Freedom Forever
Planset Revision Letter

6/29/2023
REV #2

KONG THAO
300 HORSE WHISPERER LANE, LILLINGTON, NC 27546

ROOF PLAN WITH MODULES LAYOUT

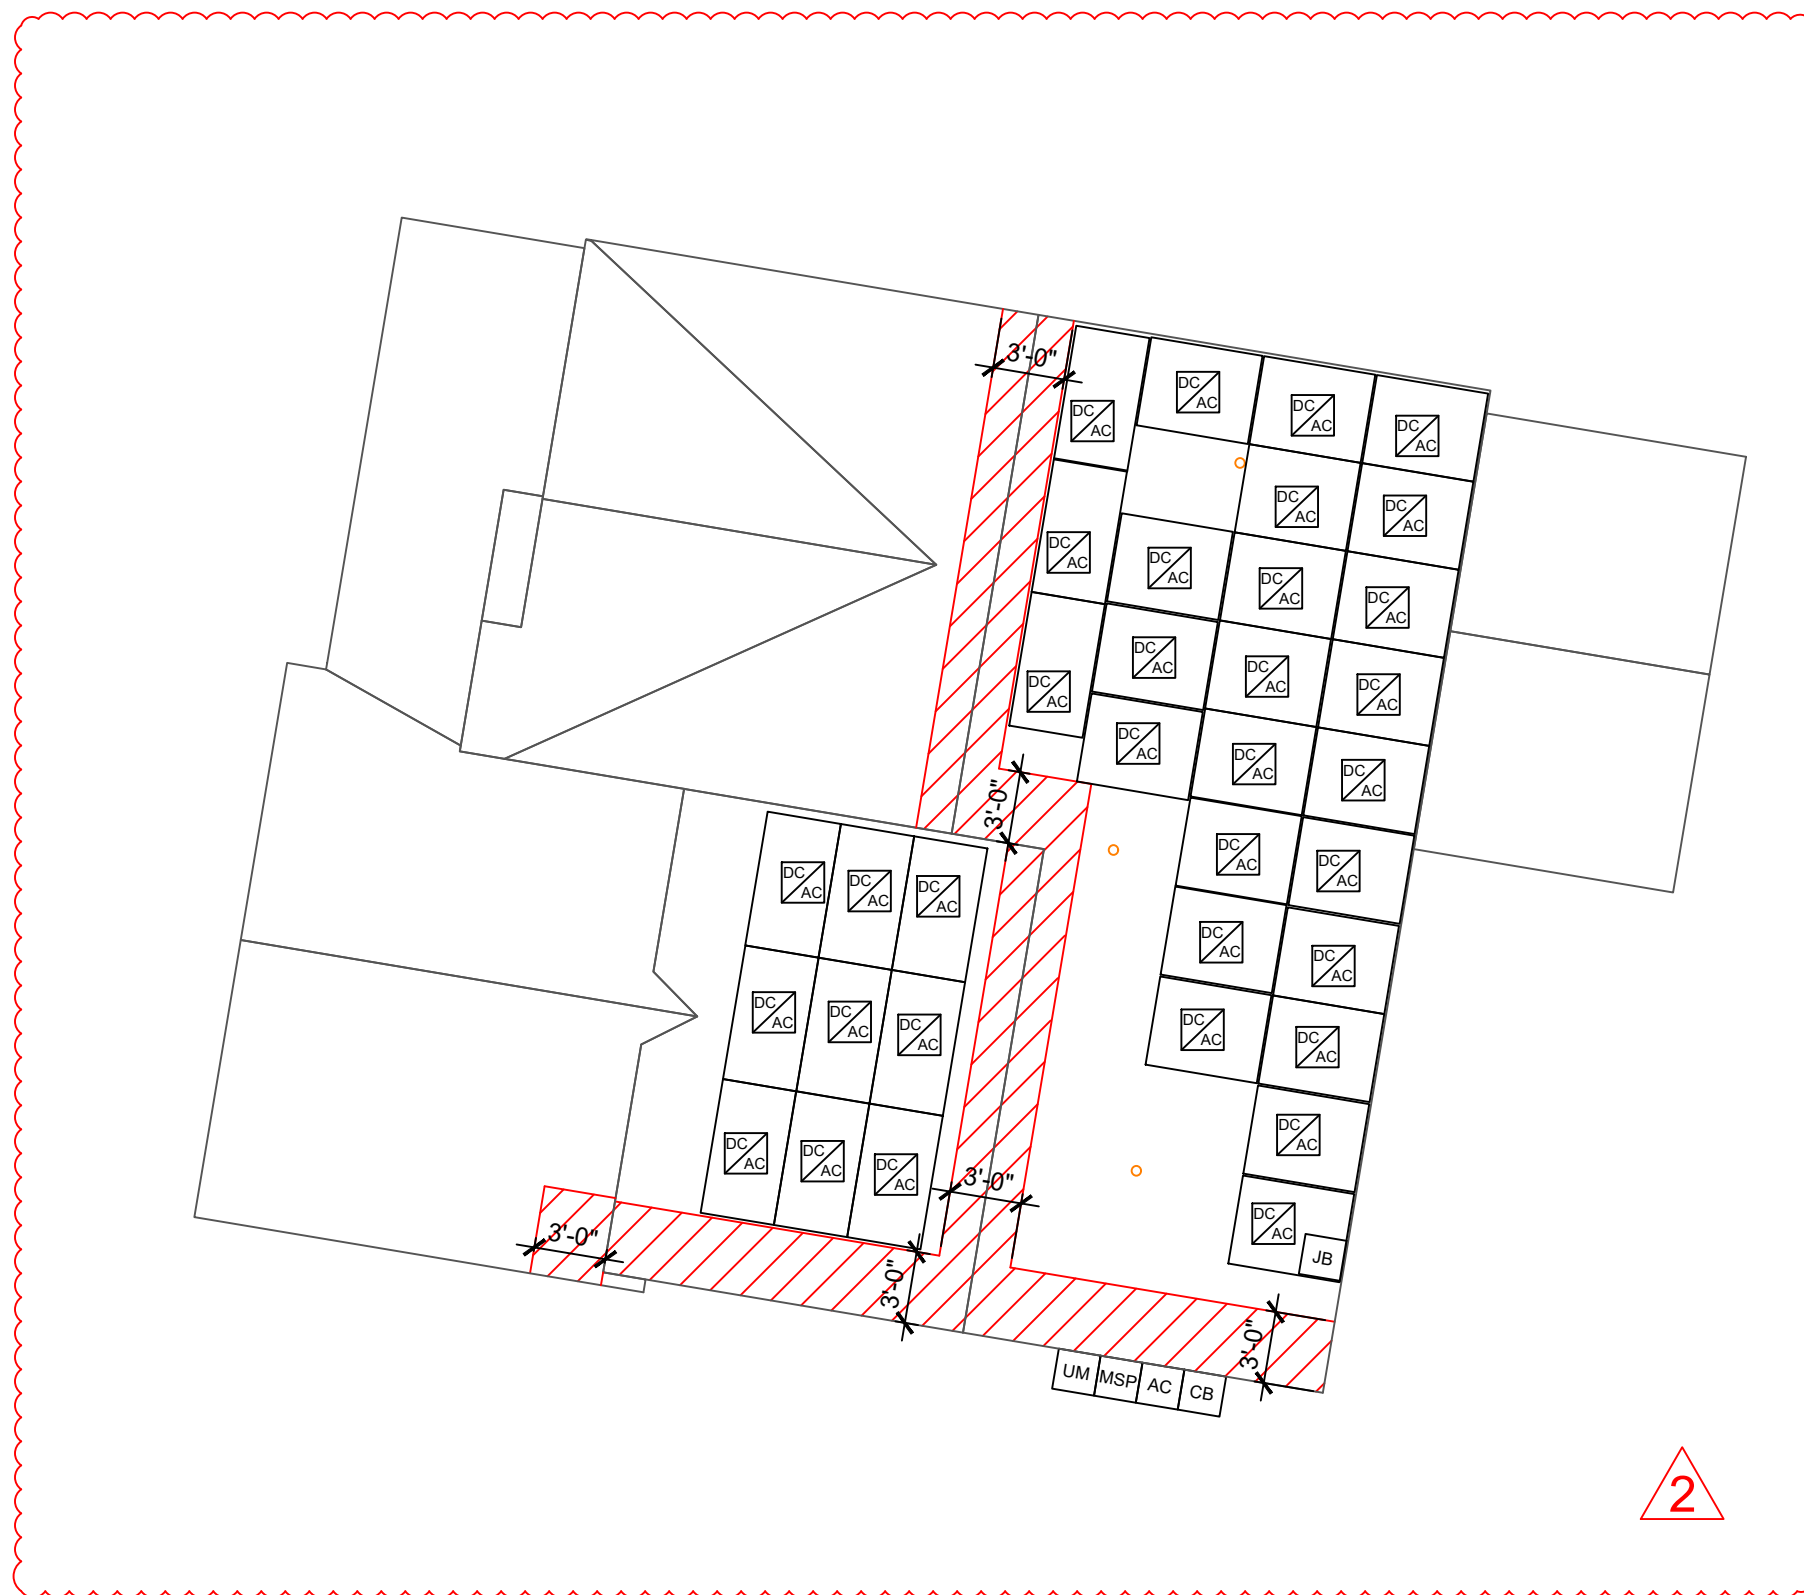
Layout change

All corresponding changes are notated on the plans by revision clouds.
